COMMUNITY DEVELOPMENT DEPARTMENT
501 Delta Avenue ♦ Marysville, WA 98270 ♦ (360) 363-8000

Re: Stack Short Plat (SP22006) 2nd Submittal Technical Review Comments

RE: Stack Short Plat, File# SP22-006
5 Lot Short Plat
3807 122nd Street NE & Parcel # 30050900202200

**RD-01**

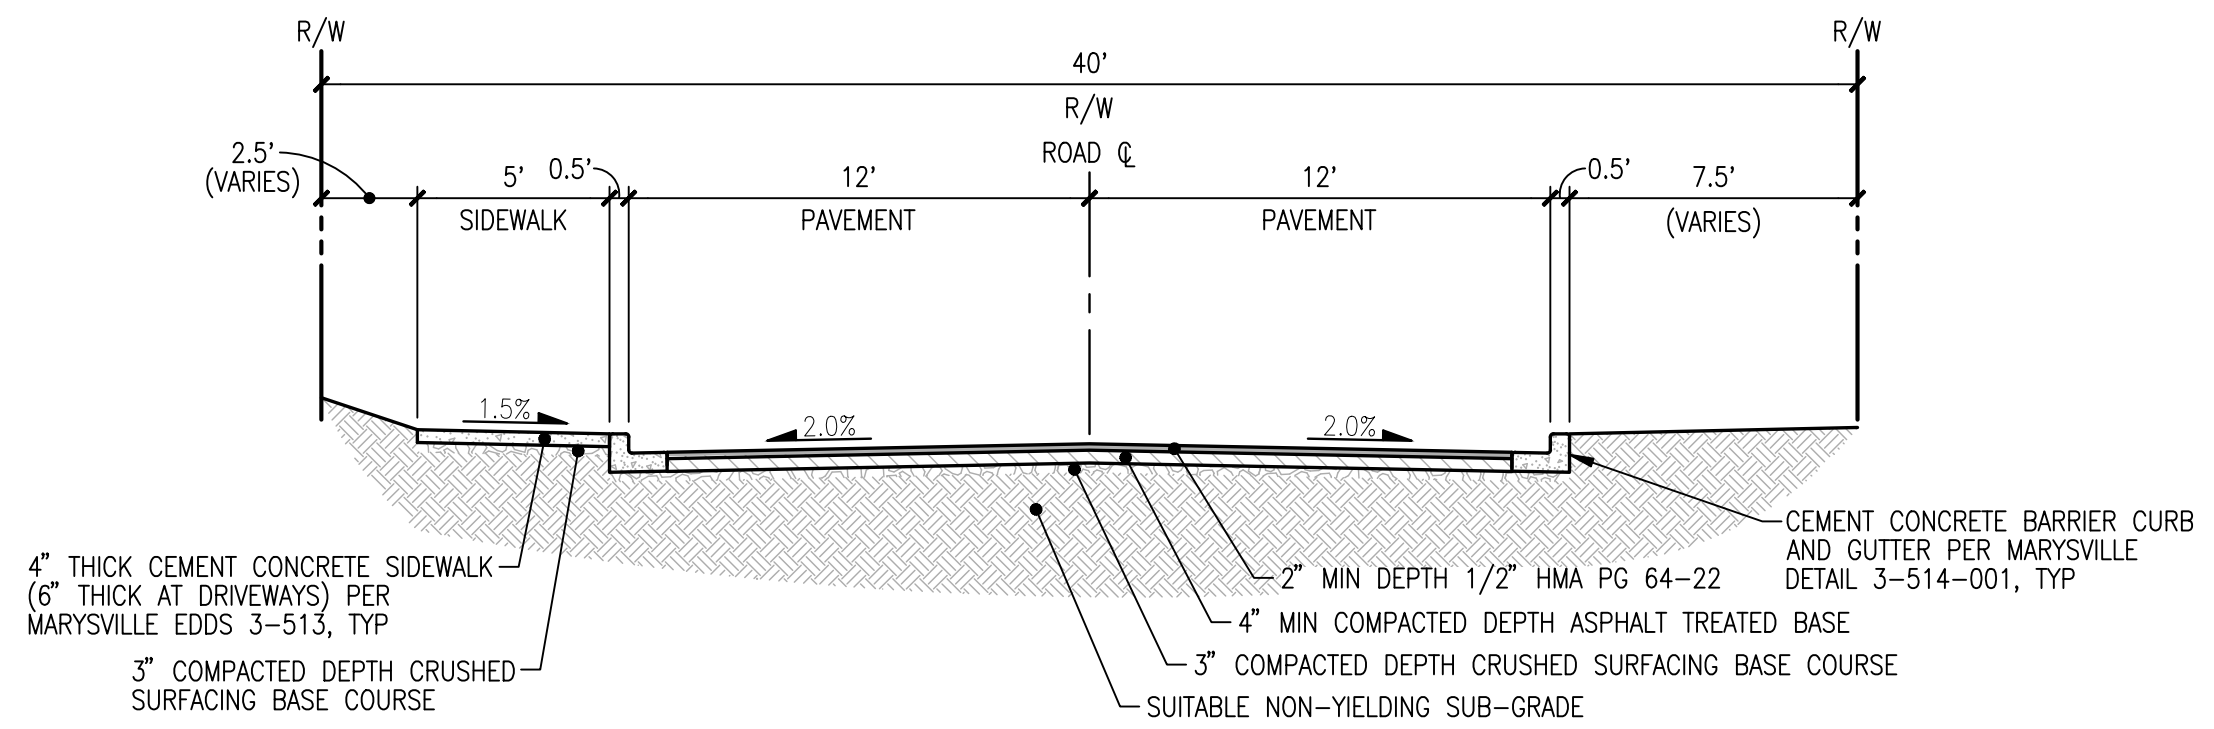
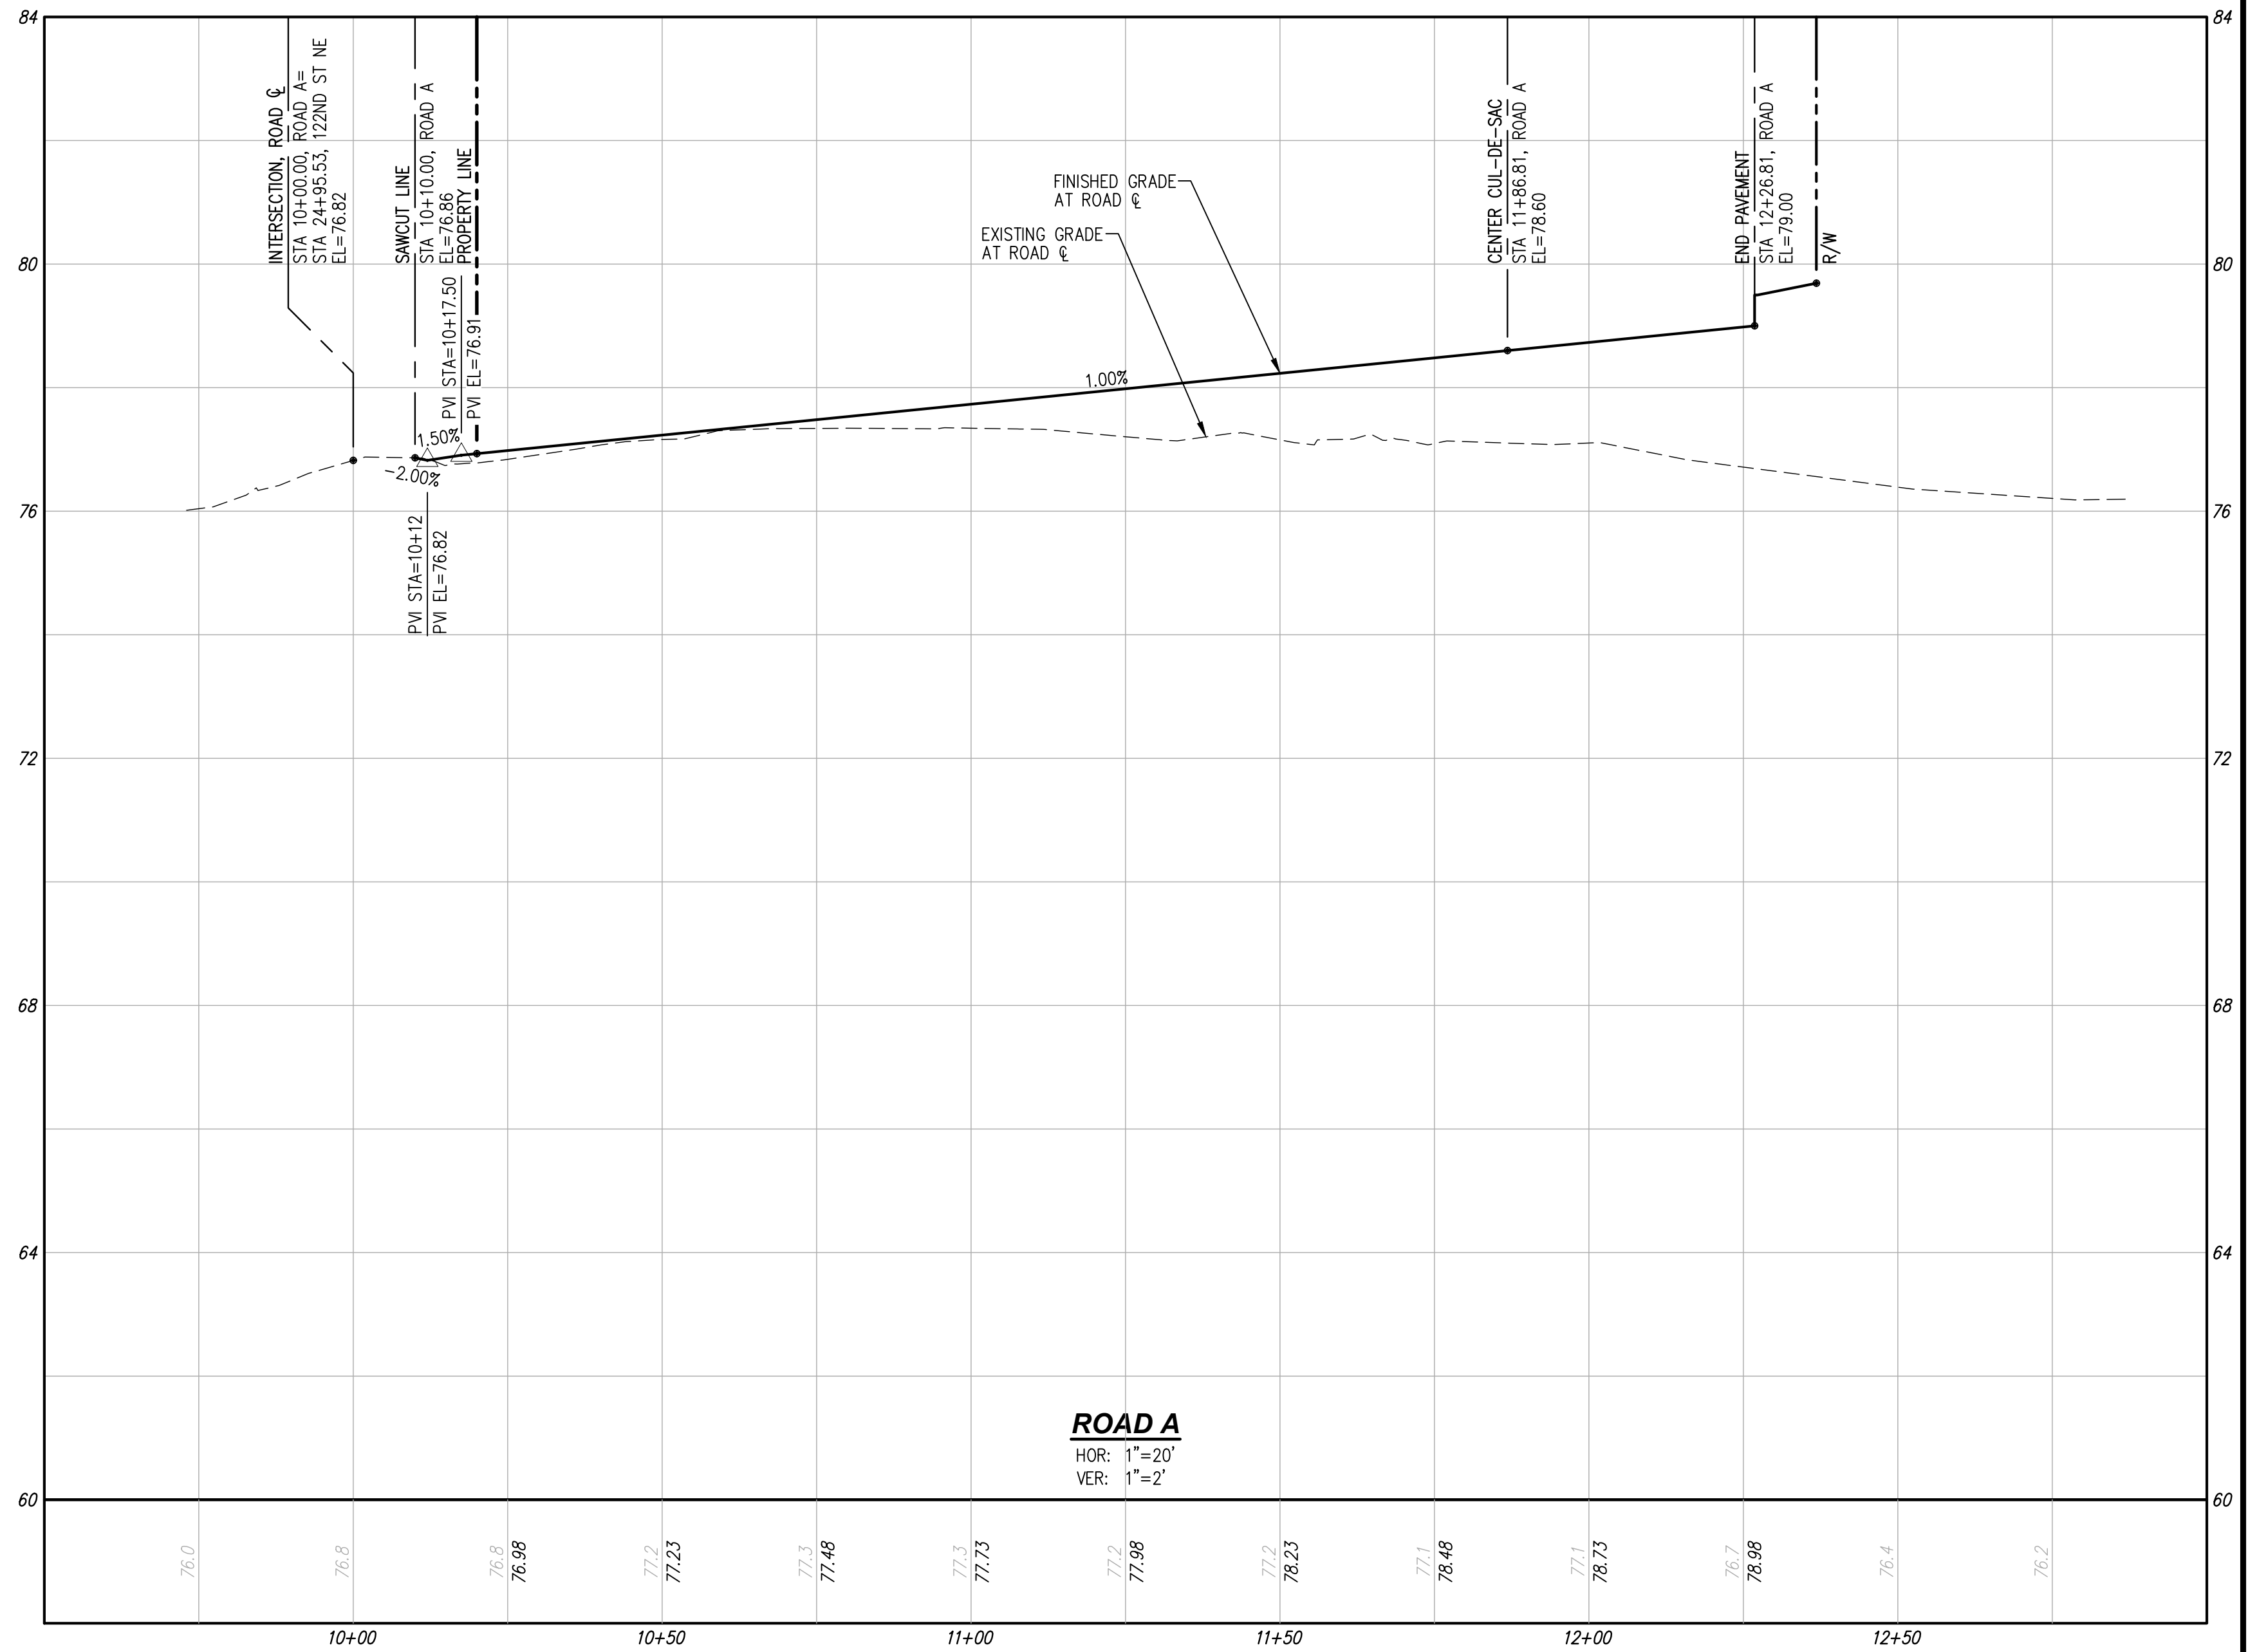
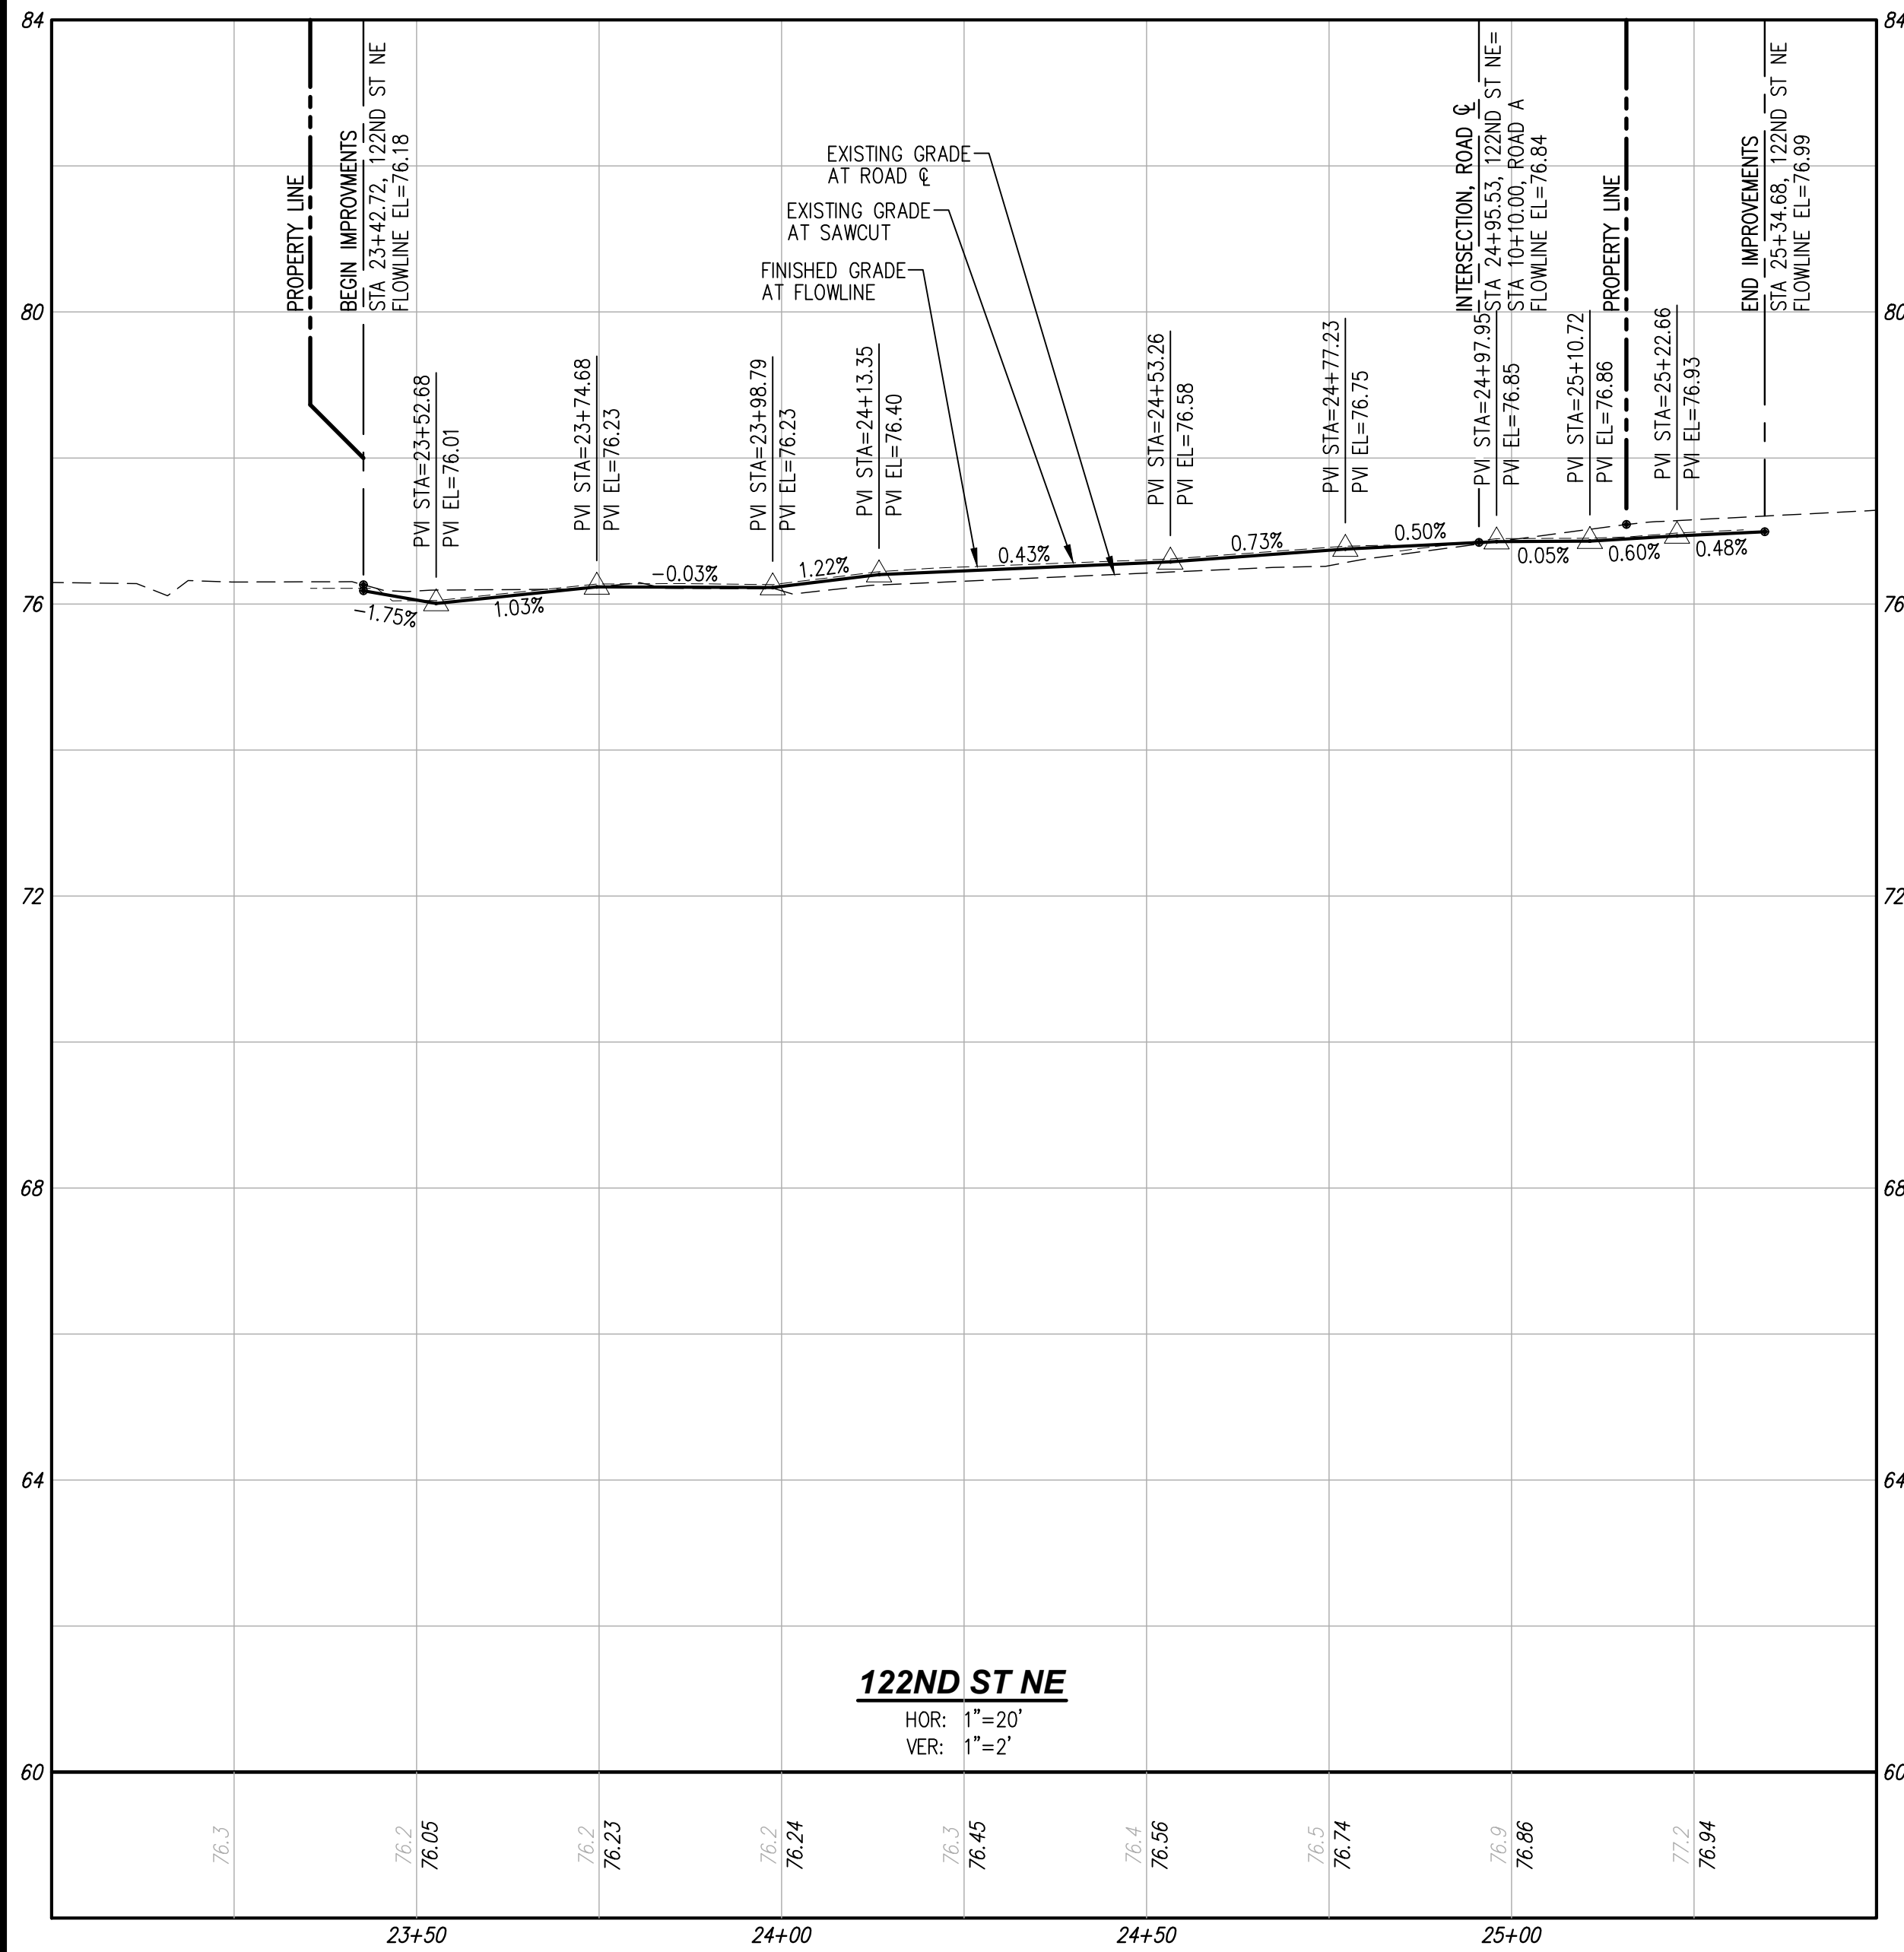
- b. The new road shall be constructed in accordance with standard plan 3-202-003. The cul-de-sac shown must be compliant with standard plan 3-207-001.

- 1) Cul-de-sac sidewalk Variance:
 - a. Public Works Traffic Division does not object to Variance request if sidewalk is fully extended along full frontage of all residential lots including Lot 5.

2. Given curve of cul-de-sac roadway, 2 street lights shall be installed at approximate stationing of 10+40 and at northern end of cul-de-sac.
 - b. Snohomish County PUD Process:
